**TEMPORARY CONSTRUCTION ACCESS
FORD LANE, YAPTON, WEST SUSSEX**

**DESIGNER'S RESPONSE TO ROAD
SAFETY AUDIT STAGE 1/2**

Report No.: 18-344-14

Date: October 2020

LARGE TIPPER: LEFT TURN IN

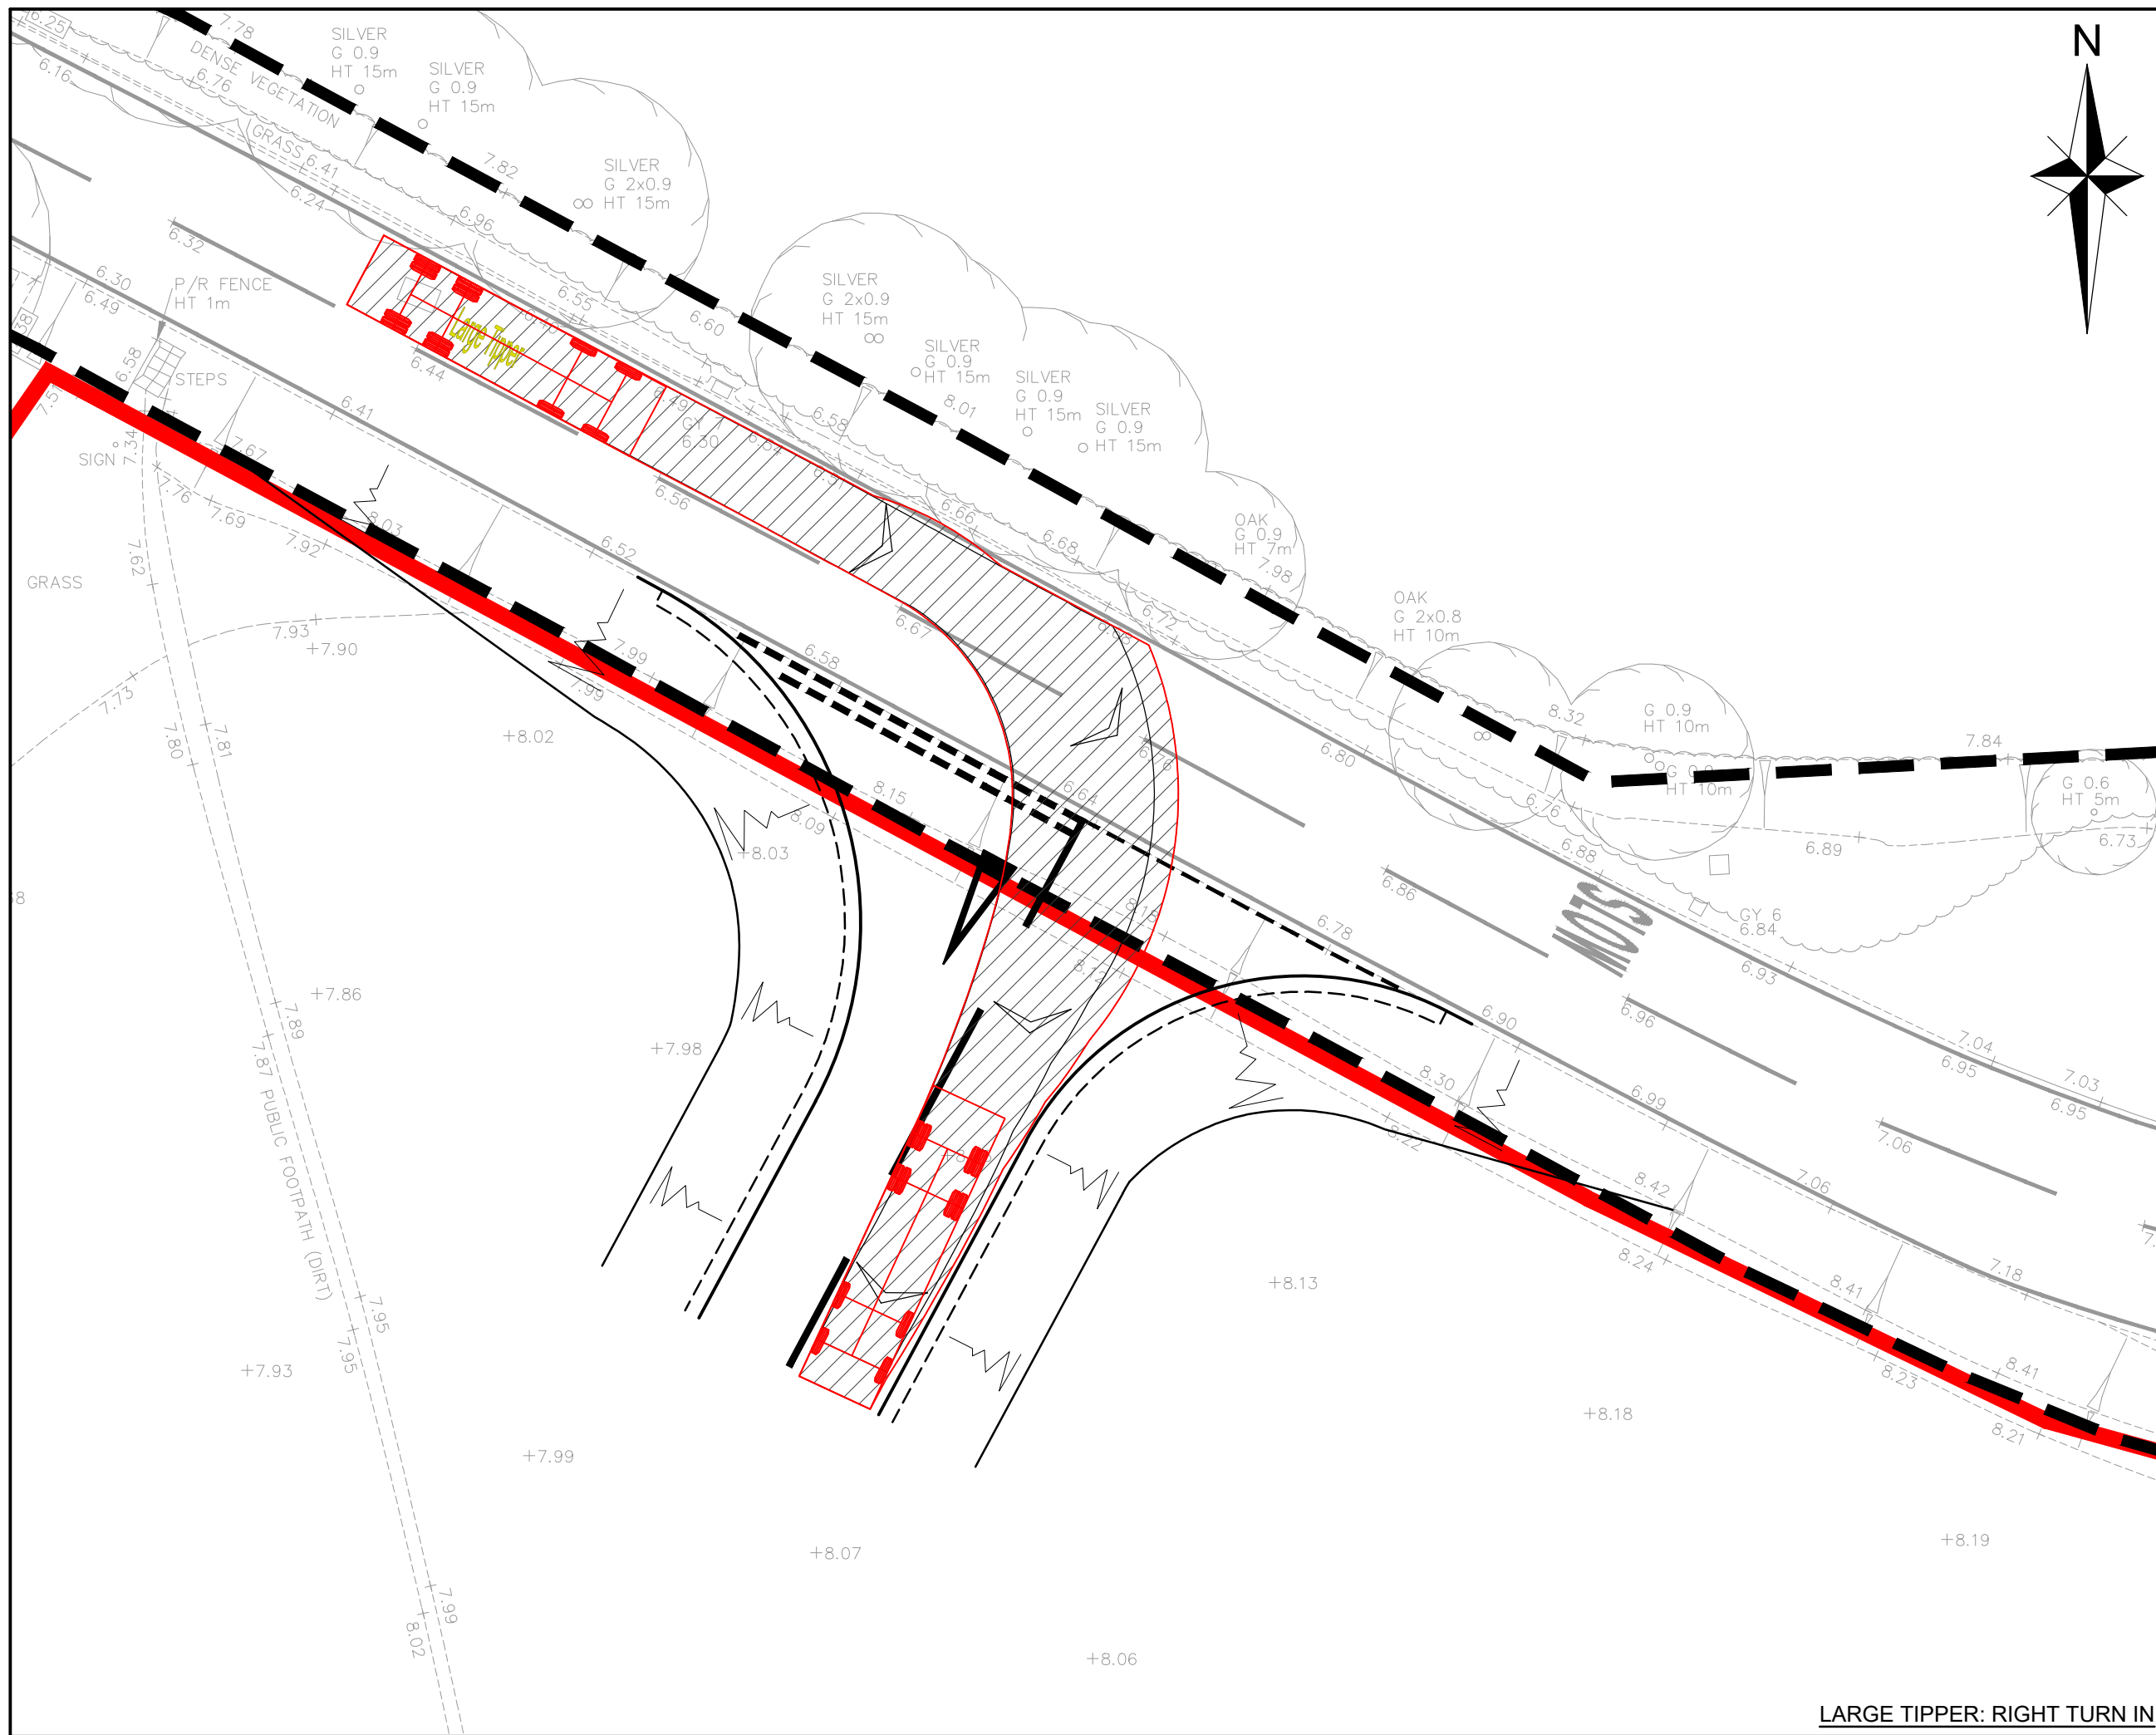
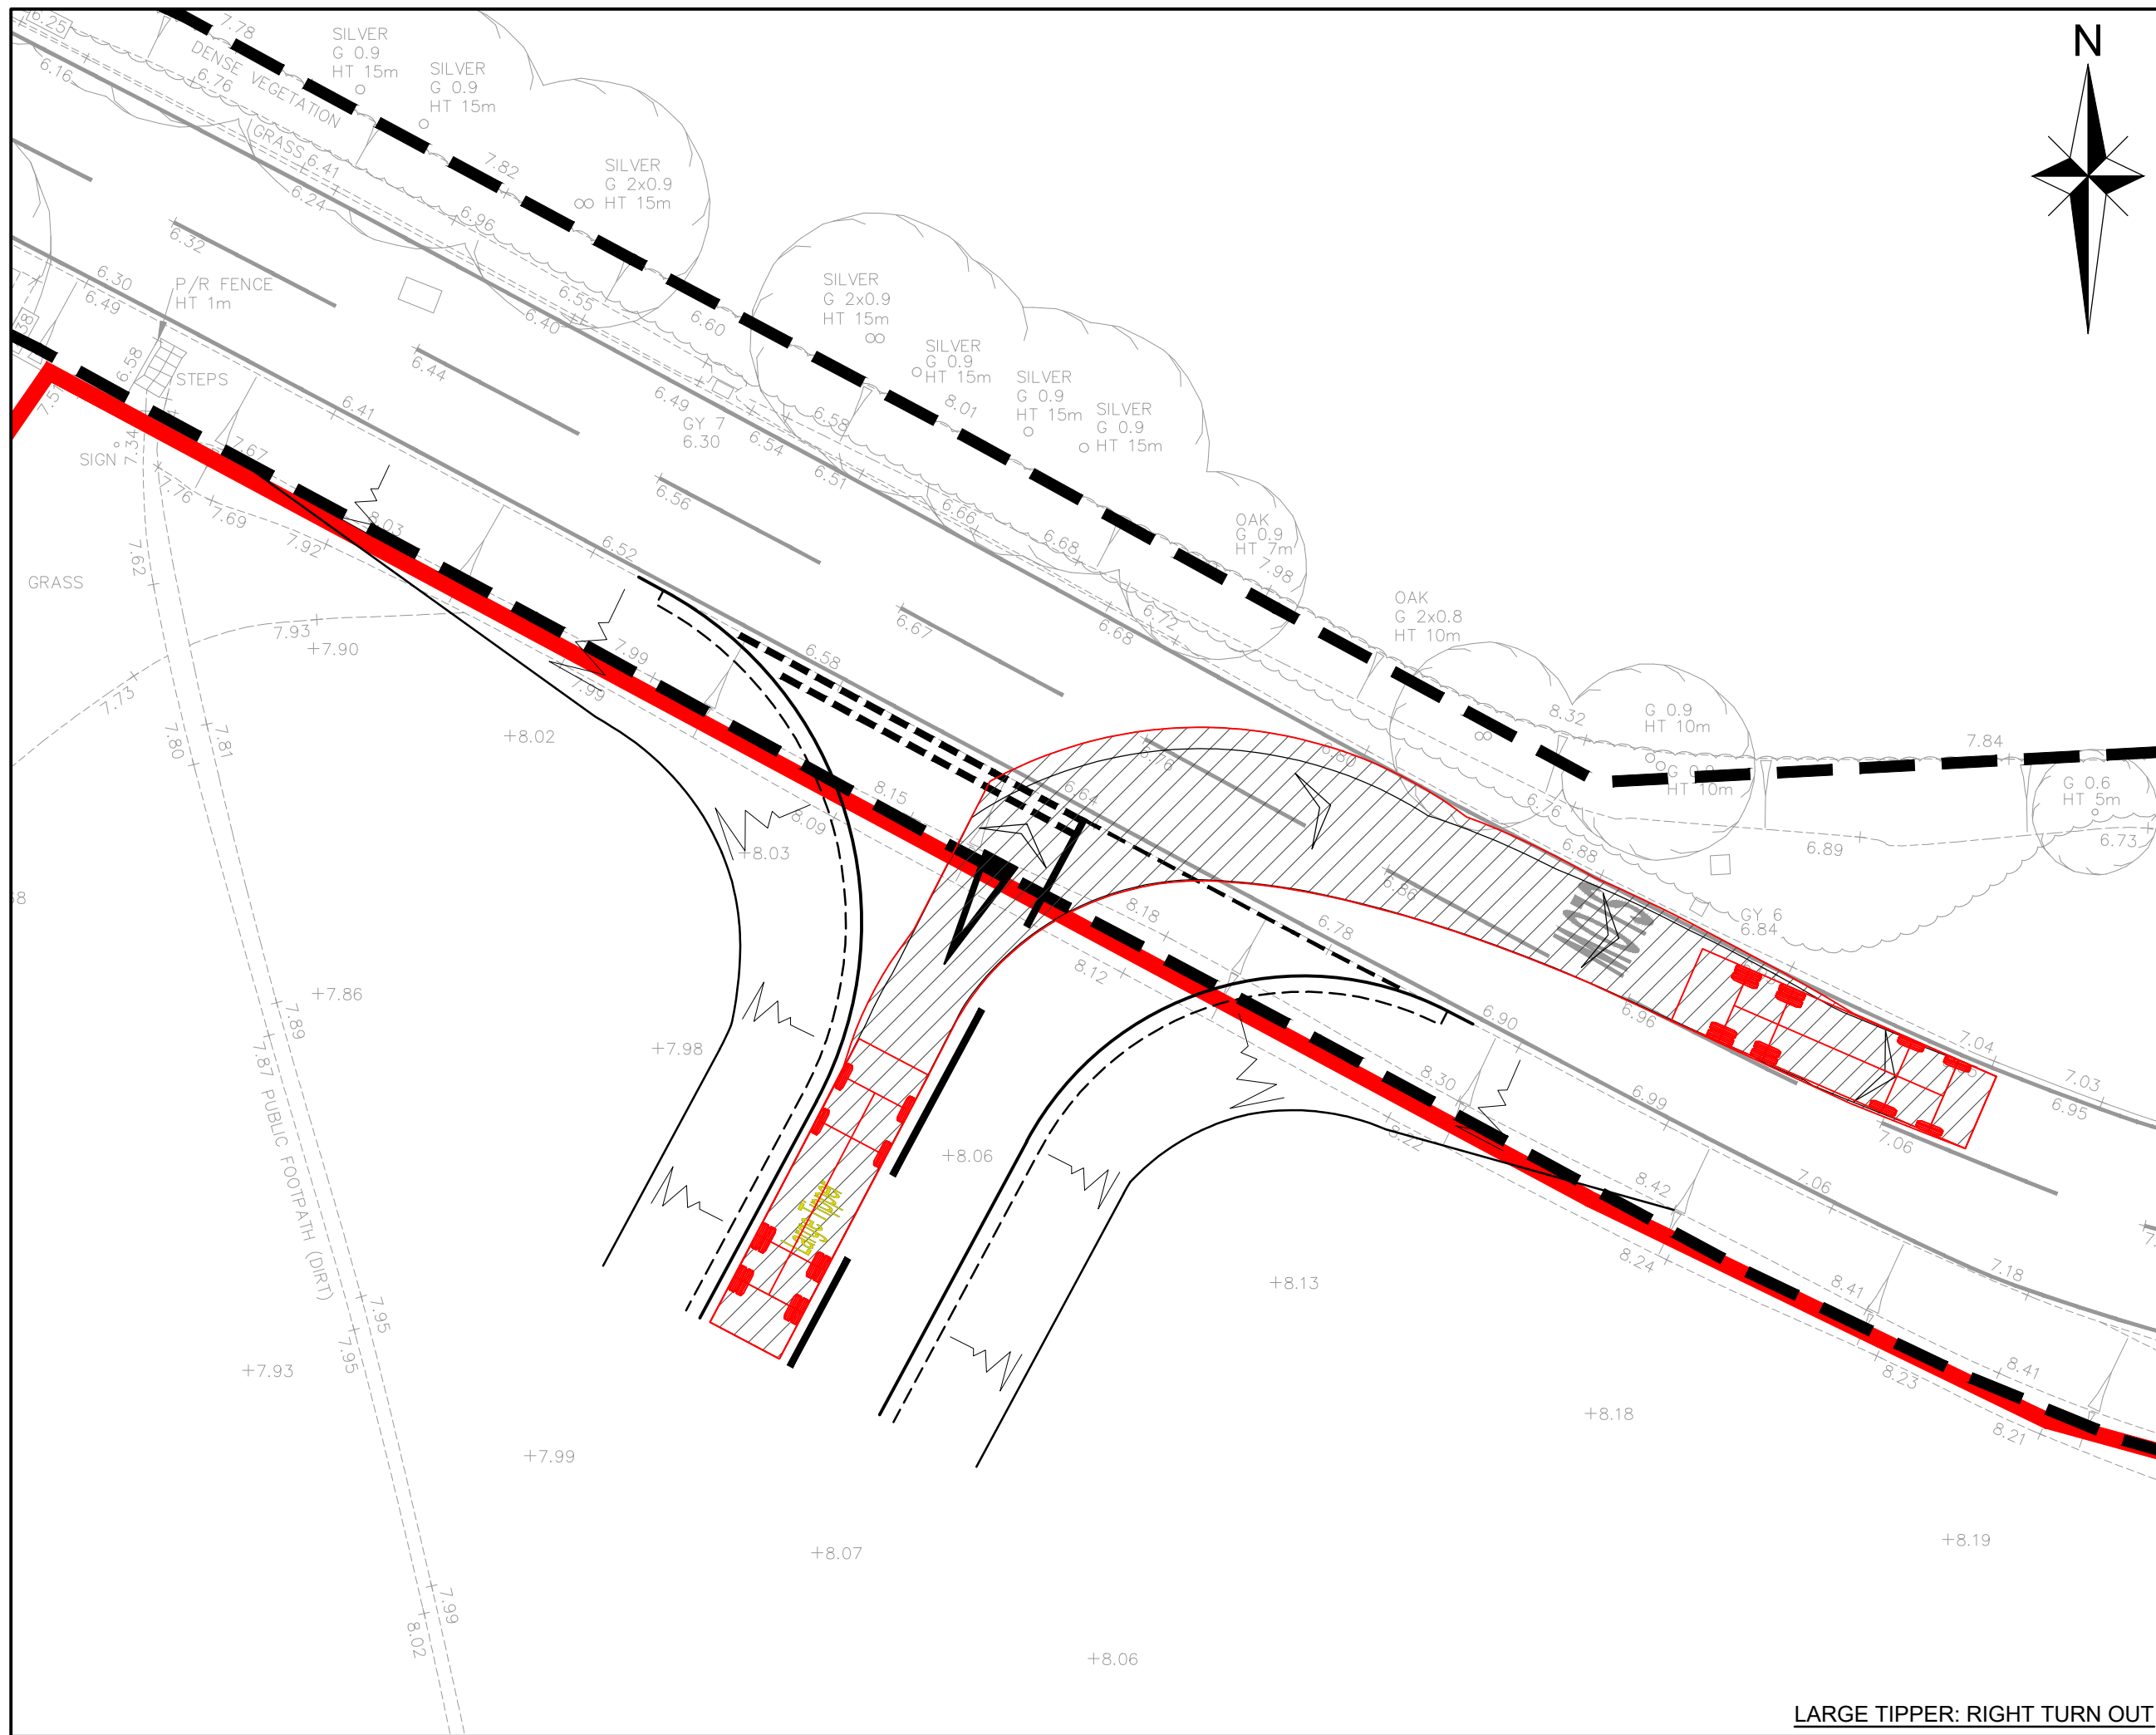
Audit Item No.	RSA Problem	RSA Recommendation	Design Organisation Response	Overseeing Organisation Response	Agreed RSA Action
3.2	LOCAL ALIGNMENT				
3.2.1	PROBLEM Location: At the proposed access. Summary: Insufficient carriageway space could lead to rear end shunt head on or side impact collisions. The proposed temporary access is shown as being 5.5m in width and has a 6m radius on the south eastern side of the junction. Swept paths provided show marked deviations in paths taken to make the turns into and out of the temporary access., which could lead to head on collisions. There is concern that at 5.5m in width with the current radii that two-way HGV operation of the access will not be possible.	It is recommended that the temporary access and associated radii should be capable of accommodating simultaneous two-way HGV movements.	The junction layout is typical for this type of access/use. Provision of a layout to simultaneously accommodate two HVGs would make the access unnecessarily oversized and could lead to increased vehicle entry/exit speeds.	Radii and width have been increased to accommodate 2 way HGV's	Access widened to 6.5m and junction radii increased to accommodate 2 way HGV's.
